ENG-SP22003-R1-DrainageLetter redlines.pdf Markup Summary

PRELIMINARY DRAINAGE REPORT for WINDERMERE FILING NO. 2 Colorado Springs, Colorado

**REFERENCE HISTORIC MAP FOR BASIN D16 EXTENTS**

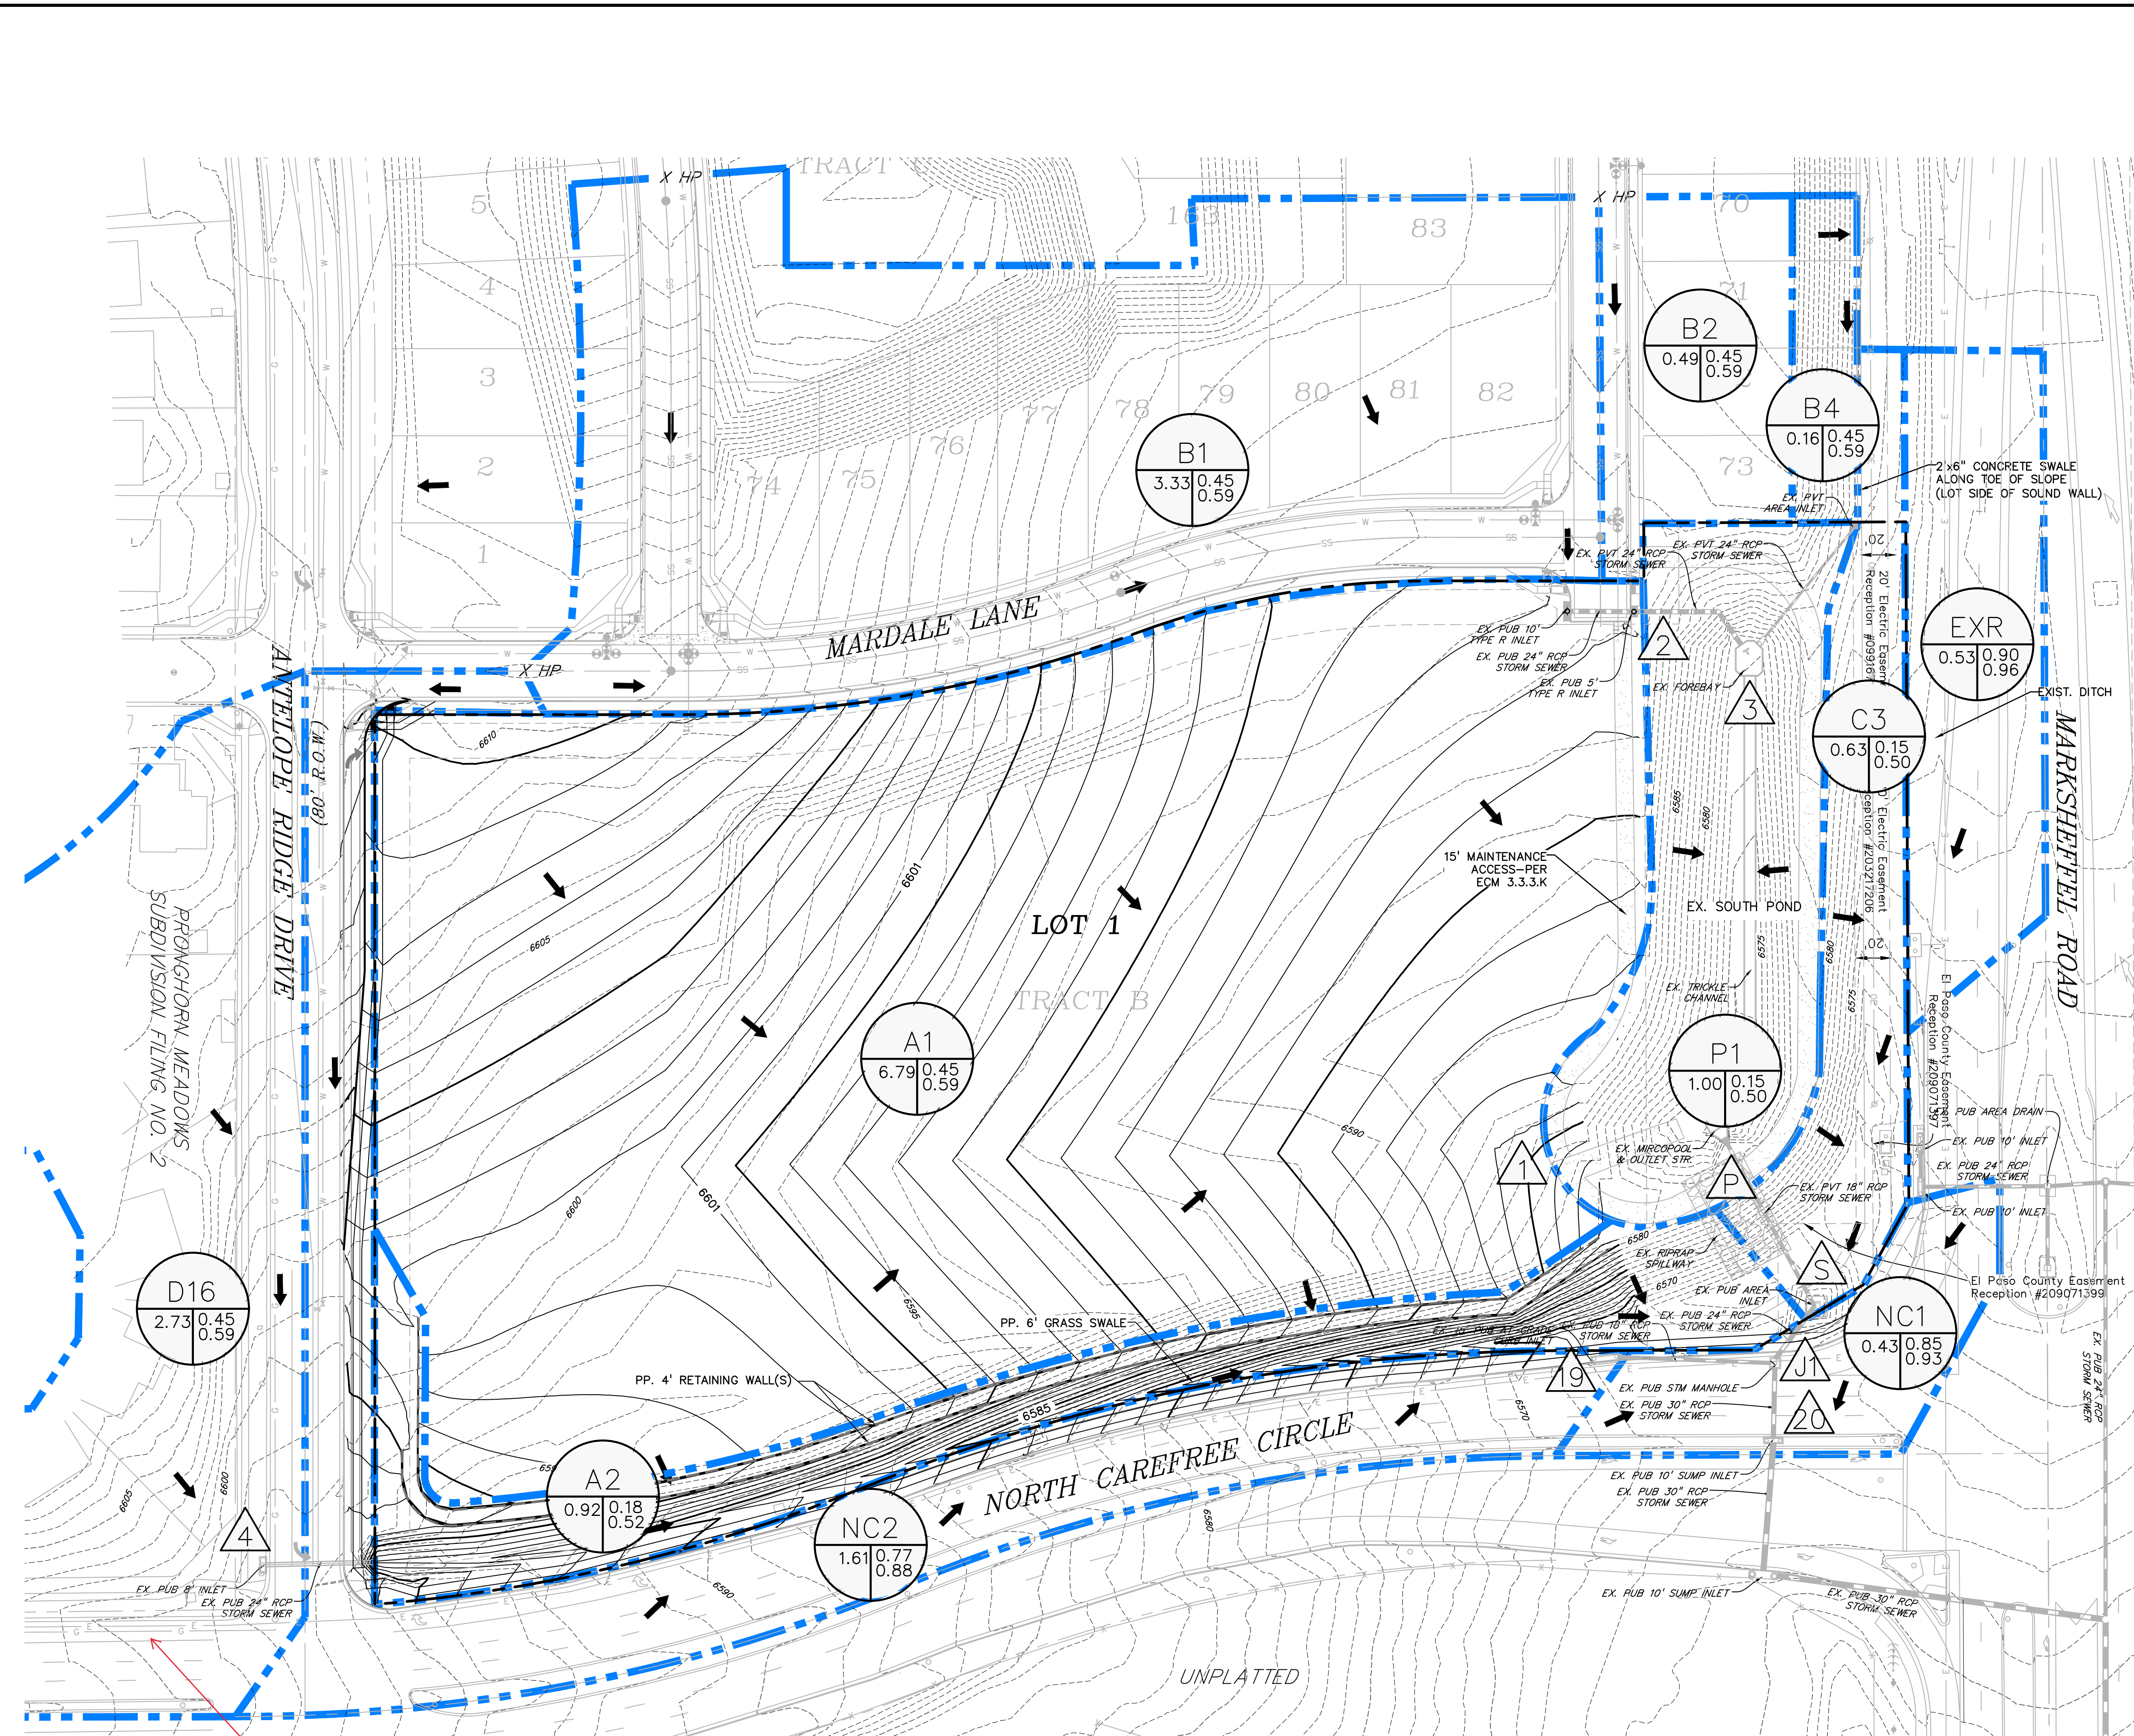
n D16 that discharges on to the Windermere property

Does this drain onto the property? If so, would it go to DP S, not into the pond?
